WELWYN HATFIELD COUNCIL – DEVELOPMENT CONTROL
DELEGATED REPORT

APPLICATION No:	S6/2008/1763/FP
------------------------	------------------------

The proposed development would involve the conversion of the existing loft space to accommodate a bedroom and ensuite bathroom. Two velux windows would be inserted into the front plane of the roof and a flat roof dormer would be built on the rear plane of the roof. The rear dormer would measure 3.4m in width by 1.8m in height with a taller section at the proposed doorway measuring 2.3m in height.

FRONT ELEVATION 1:100

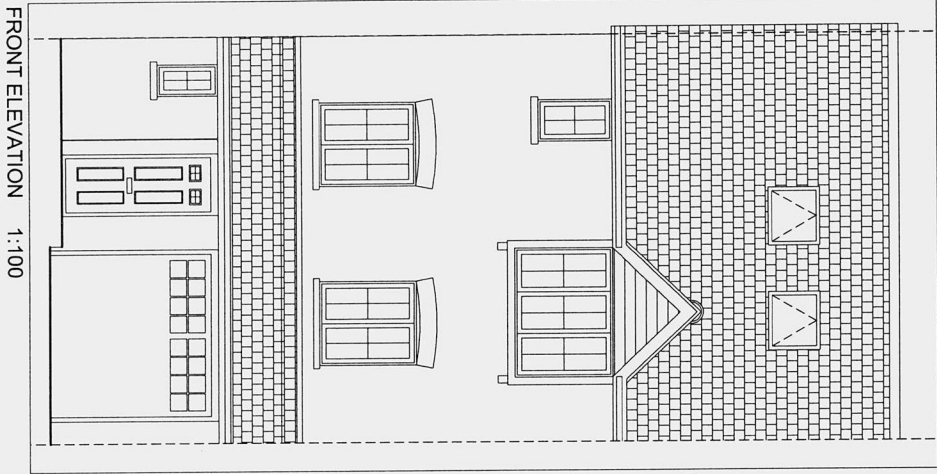
Although velux windows are not a predominant feature in the surrounding streetscene, the proposed velux windows to the front plane of the roof would not appear out of place or prominent. Due to the size and flush appearance of these

The proposed velux windows would mostly only allow a view of the sky and would not result in a loss of privacy to the neighbouring properties.

GROUND FLOOR PLAN 1:100

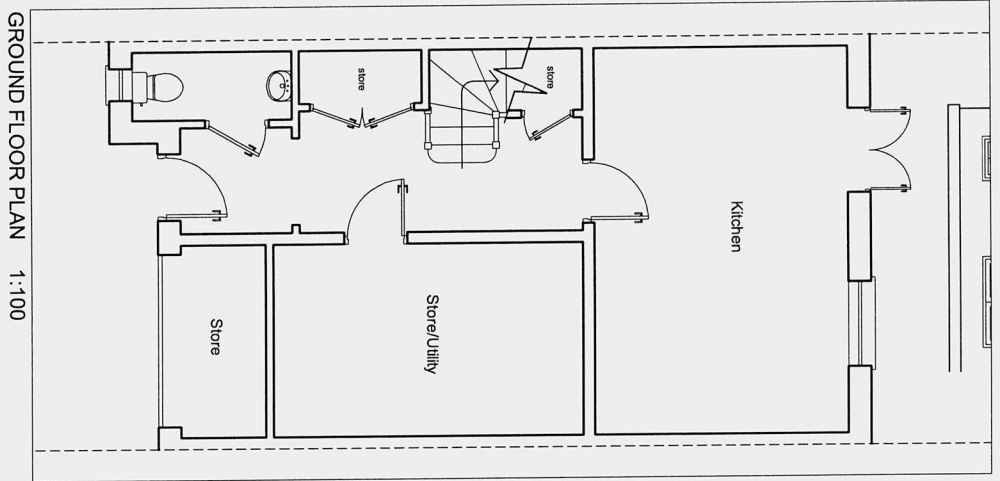
3. The application dwelling appears to have a garage and two spaces to the front of the dwelling. However, the plans illustrate that the garage has been converted to accommodate a shallow store and one of the parking spaces straddles the boundary with the adjacent plot to the north. The application plot therefore only has 1 off road parking space, to serve what is at least a four bedroom dwelling as existing. The area of the application site is not zoned within the parking standards of the Welwyn Hatfield District Plan 2005, however, the parking standards stipulate a requirement of 2 spaces for 4 or more bedroom dwellings in the most accessible parts of the district. When considering the location of the application site, the proposed parking provision would not be adequate and would not meet the requirements of Policy M14 of the Welwyn Hatfield District Plan 2005.

REAR ELEVATION 1:100

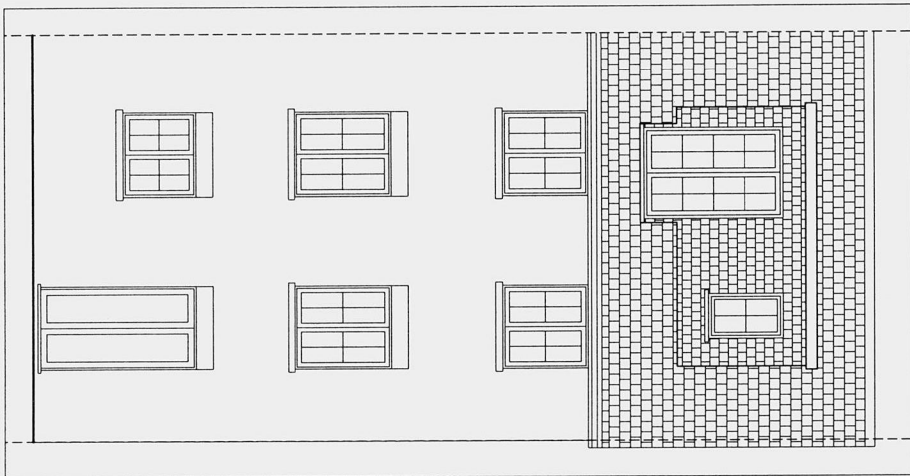
The proposed dormer window would be a large flat roofed addition, which has not replicated any additions or design features present on the adjacent properties. Due to the size and height of this addition it would be particularly prominent and give the dwelling a 4 storey appearance, which would be overly dominant when compared to the existing dwelling and adjacent properties. The design of the proposed dormer is partly worsened by the full height doors, which would have a greater height than the rest of the dormer. The resultant tall and over dominant appearance would not be in keeping with the character of the existing dwellings and would have an inappropriate appearance, which would be viewed within close proximity from the neighbouring plots. Furthermore, glimpse of the proposed dormer would be visible through the gaps between the dwellings on Great Braitch Lane and have a detrimental impact upon this streetscene.

The rear dormer would have an unacceptable impact in principle due to it height and the limited distance separating the neighbouring properties. In addition to this the design would worsen the impact upon the neighbouring properties. The proposed full height doors would allow a greater view and allow people to stand in a prominent position, which would overlook the adjoining occupiers.

The proposed rear dormer would fail to reflect the existing design and appearance of the application dwelling and neighbouring properties. By virtue of the proposed dormer's size and design, it would not appear subordinate or subservient to the existing dwelling and roofslope. The proposed rear dormer window would therefore have a detrimental visual impact upon the character and appearance of the locality. The proposed development is therefore contrary to Policy D2 of the Welwyn Hatfield District Plan 2005 and PPS1.

The proposed rear dormer window would result in an unacceptable increase in both direct and perceived overlooking of the adjoining occupiers. By virtue of the proposed dormer's design, height above ground level and narrow separation distances from the adjacent dwellings, it would result in an objectionable loss of privacy to the occupants of the neighbouring properties. The proposal has therefore failed to meet the requirements of Policy D1 of the Welwyn Hatfield District Plan 2005 and PPS1.

THIRD FLOOR PLAN 1:100

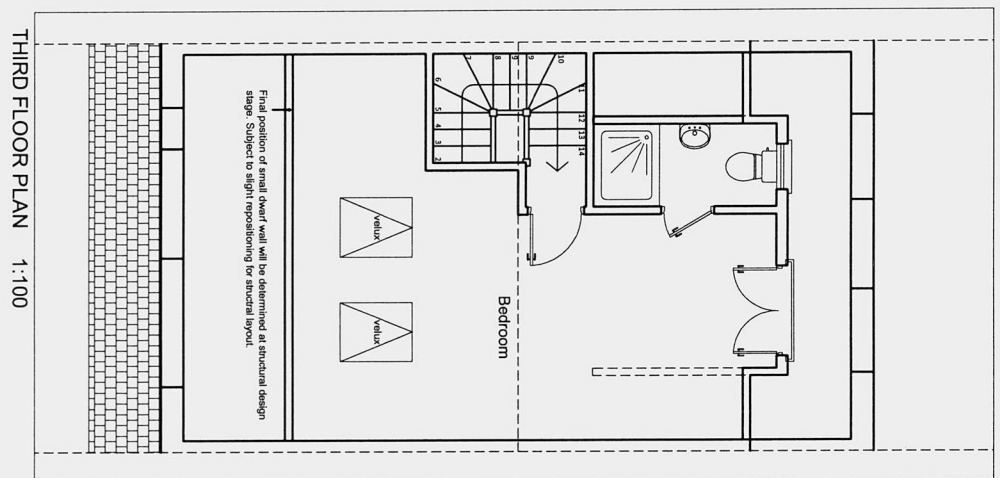
The proposed development would create an additional bedroom, resulting in a 5 bedroom property. The application dwelling would not have a sufficient provision of off road parking space for a dwelling of this size. The application would therefore fail to meet the requirements of Policy M14 of the Welwyn Hatfield District Plan 2005, Policy T14 of the East of England Plan 2008 and PPG13.
